REQUEST

Approximately 12.3 acres located along the north side of Rocky River Road and the east side of John Russell Road.

The petition proposes a residential community of up to 116 multi-family attached townhome style units and up to 9,000 square feet of non-residential uses.

# RZ-1.0

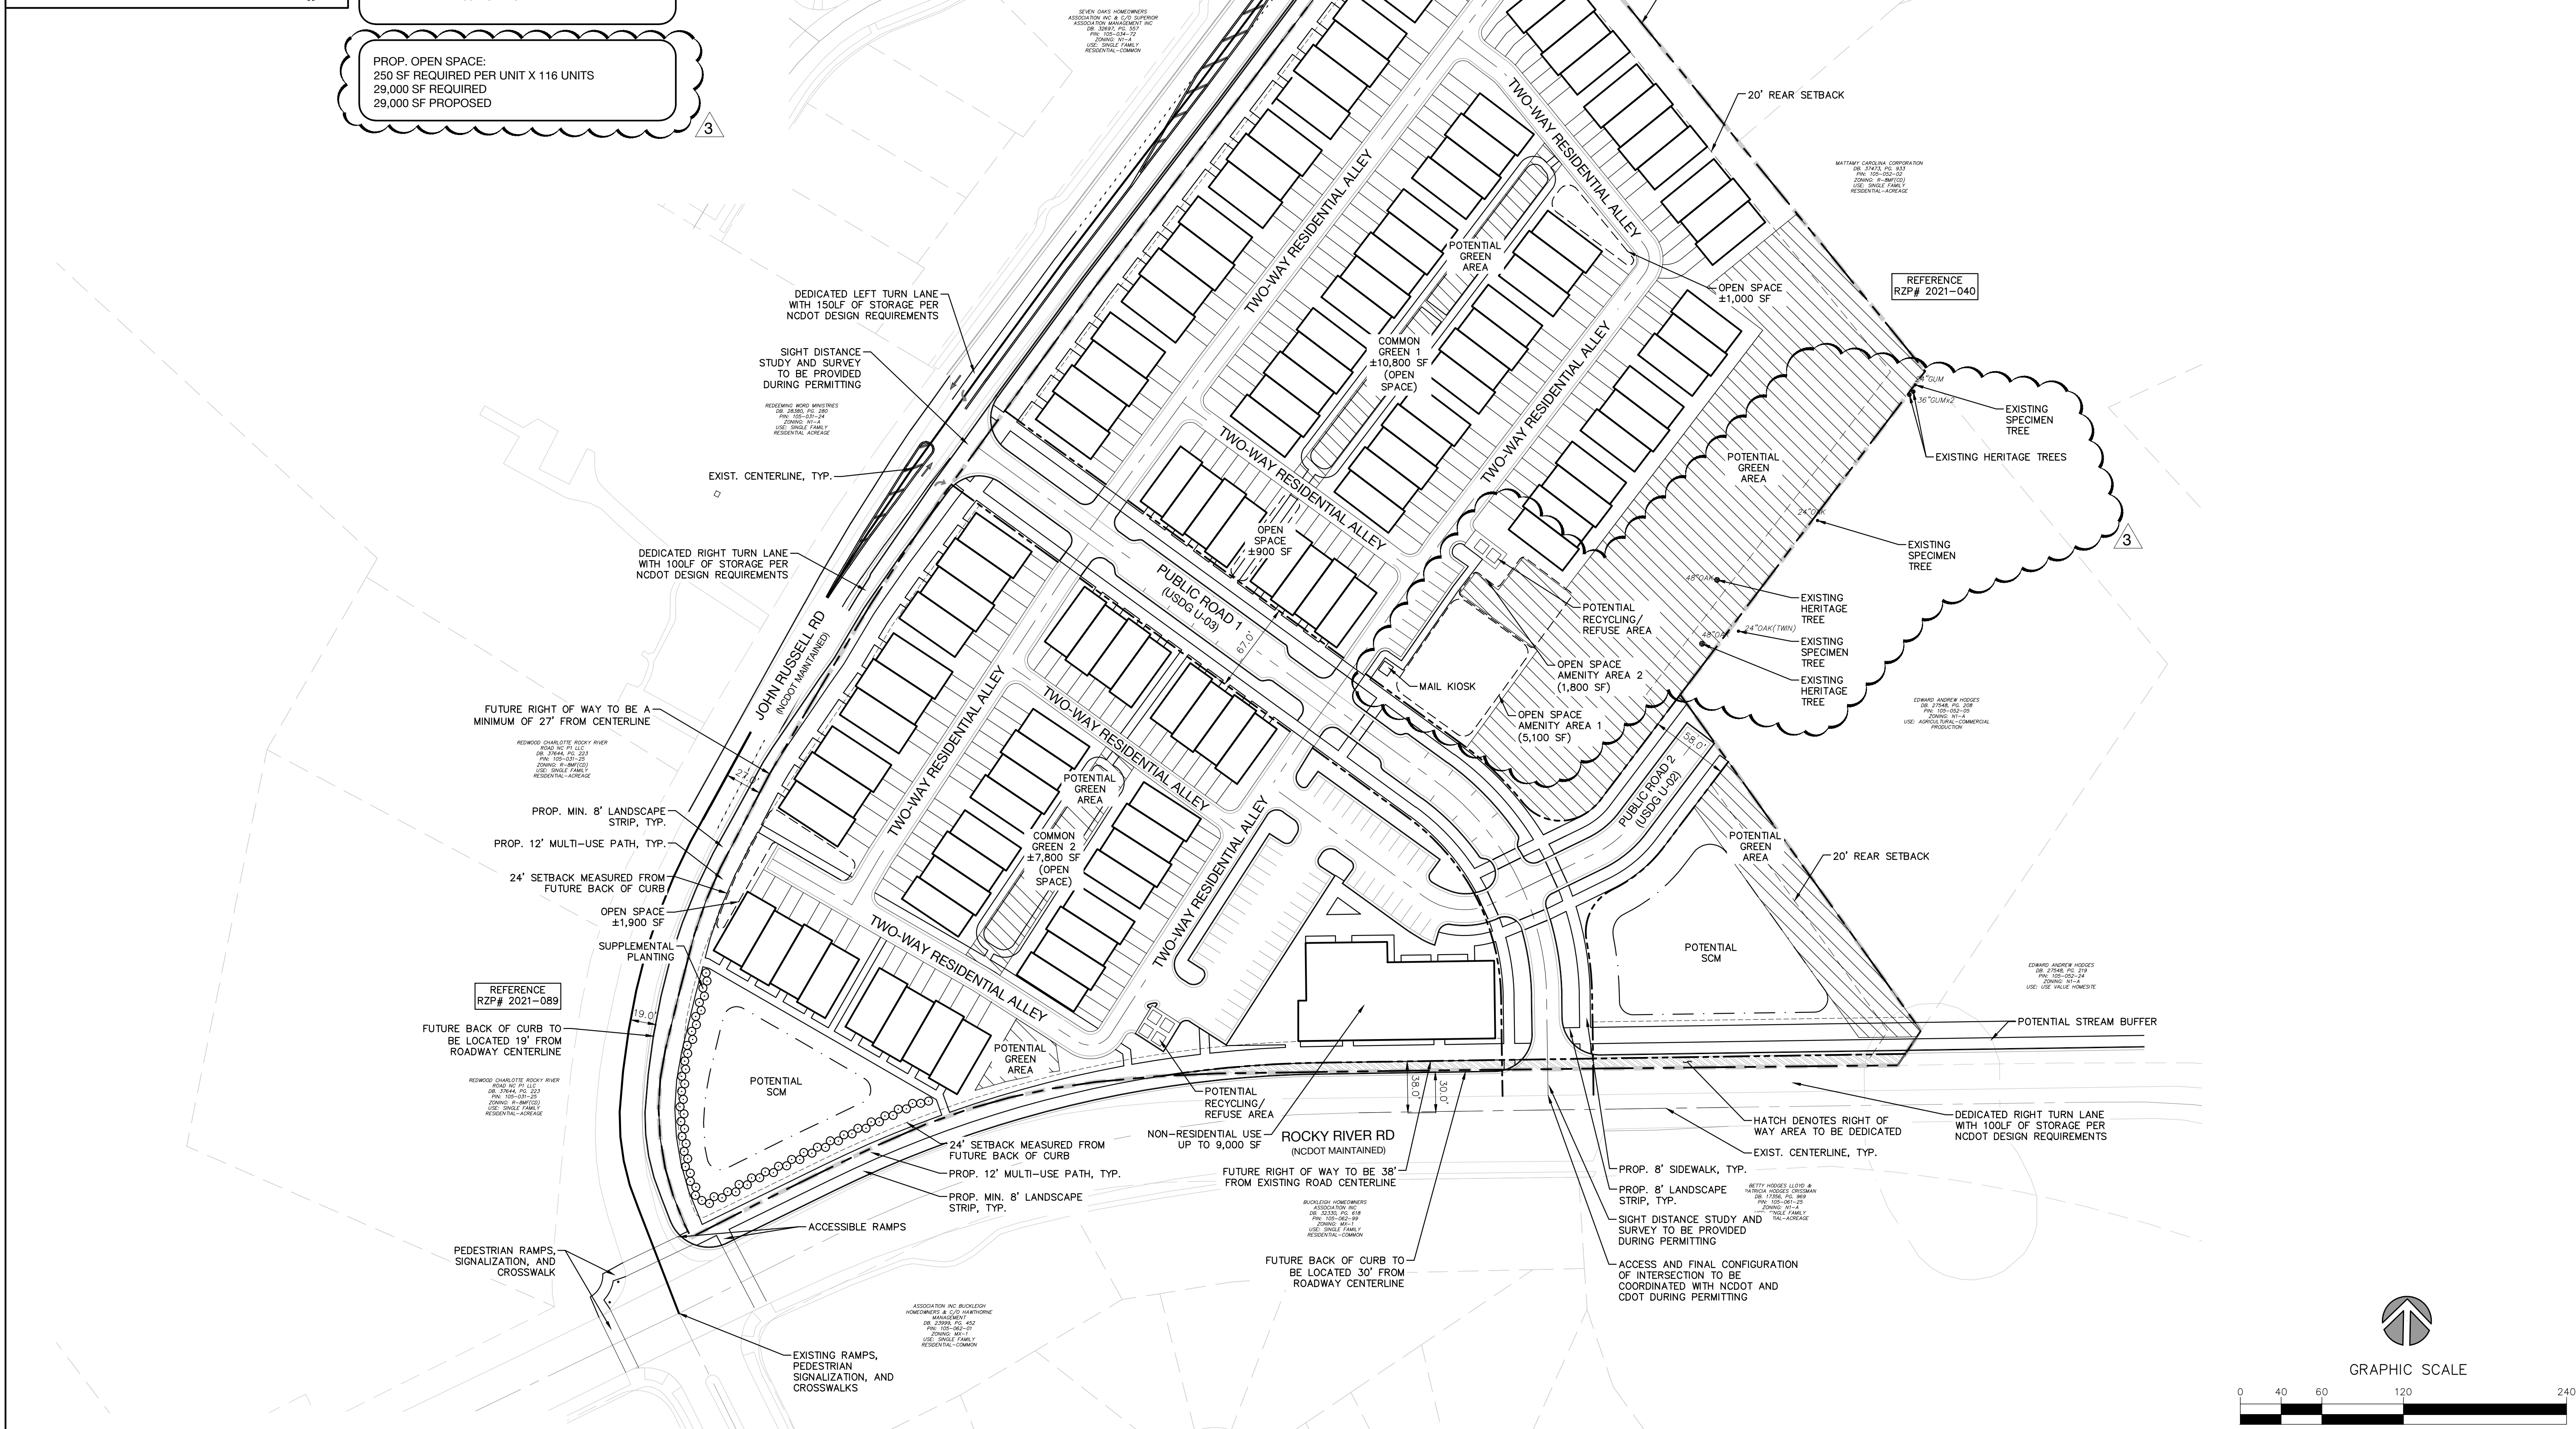
1. ~~Provide a heritage tree survey.~~ **Addressed**
2. ~~No structure (dumpster) shall be allowed within 10 feet of the tree save area.~~ **Addressed**
